URGENT - 42514/APP/2026/1963 - 23 WEST DRAYTON PARK AVENUE

I refer to the above application. Following on from my site visit, I note that the extensions built and shown on the submitted existing and proposed plans, do not appear to have been built in accordance with the approved plans (42514/APP/2025/828). The approved rear elevation is as follows:

Erection of a part single, part double storey side and rear extension and rear dormer following demolition of existing rear extension (part-retrospective).

EXISTING REAR ELEVATION.

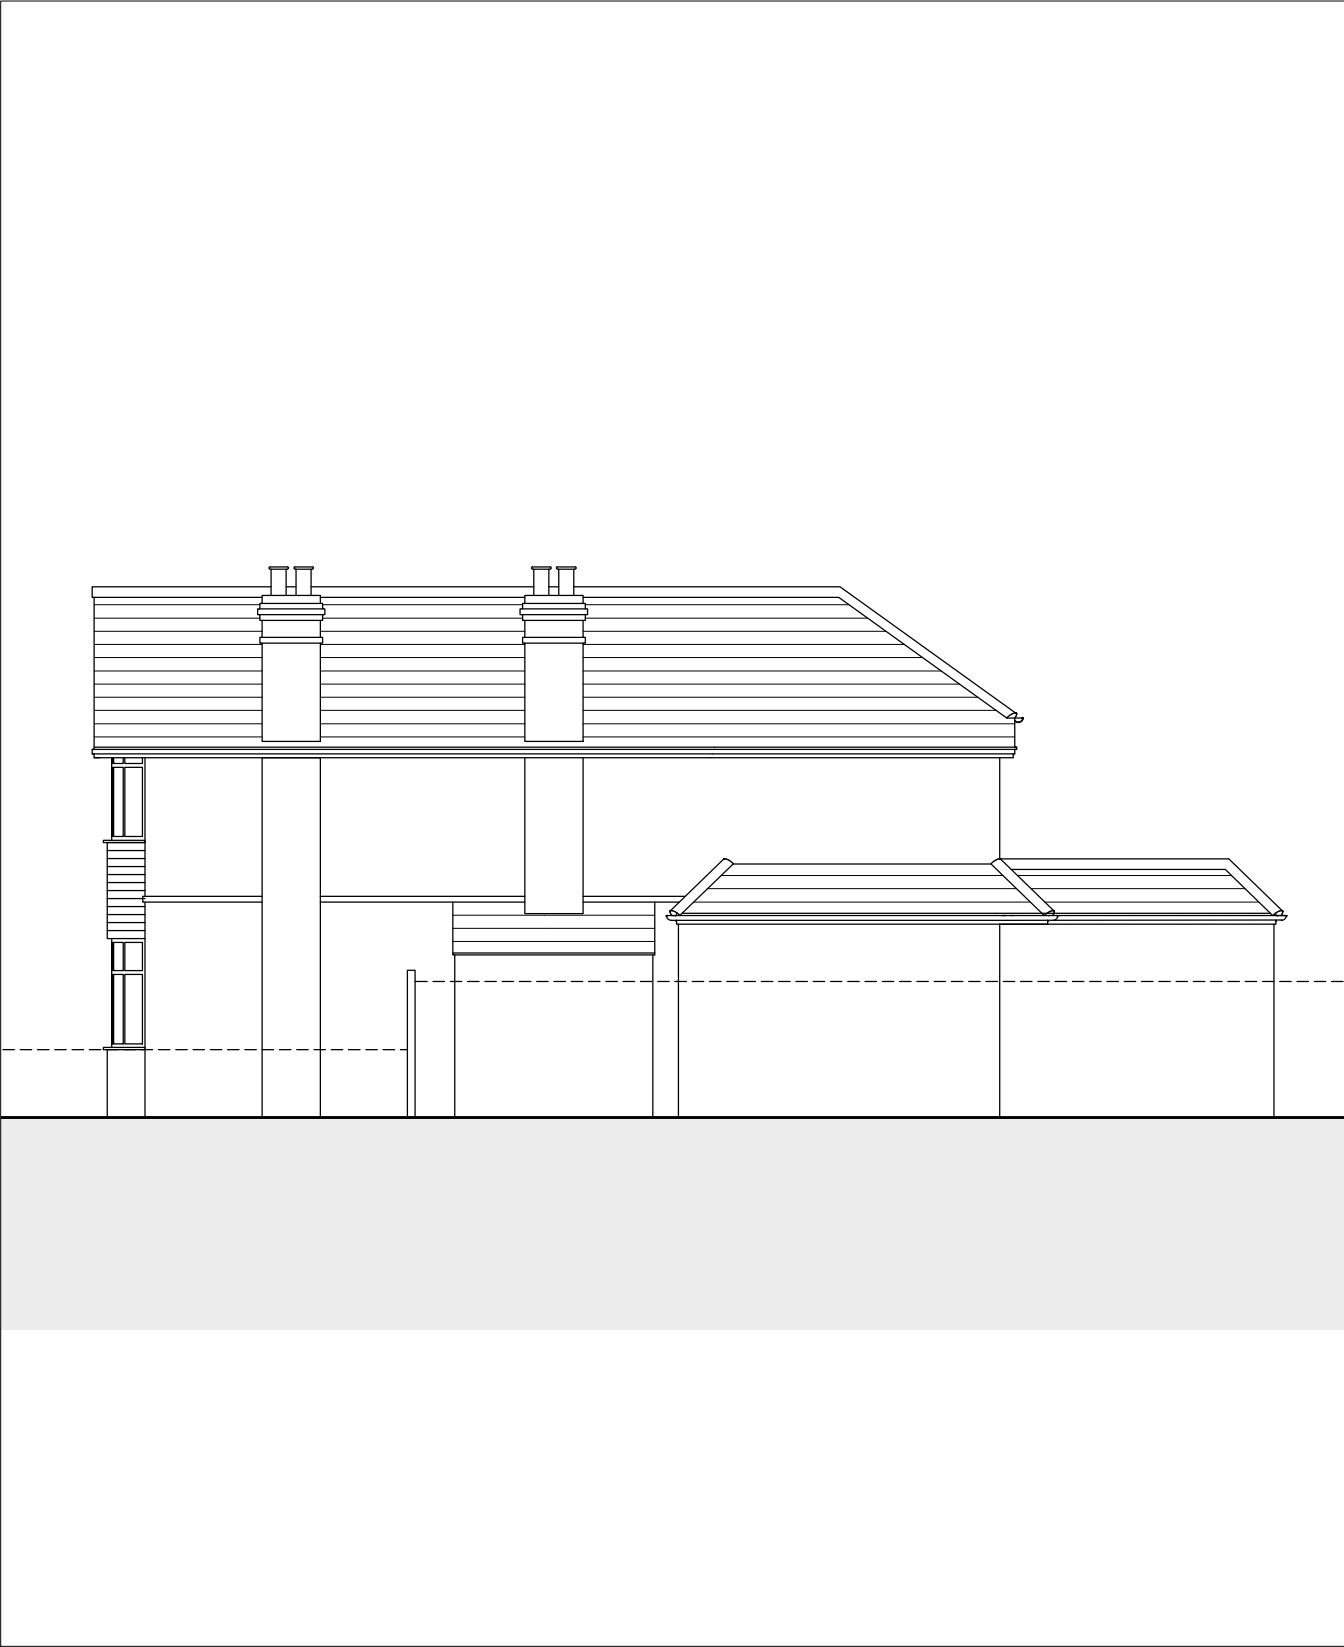
whereas the existing as built rear elevation is as:

It would be useful to submit an amended plan to outline by way of a dotted line, the approved extension on the as built and proposed plan
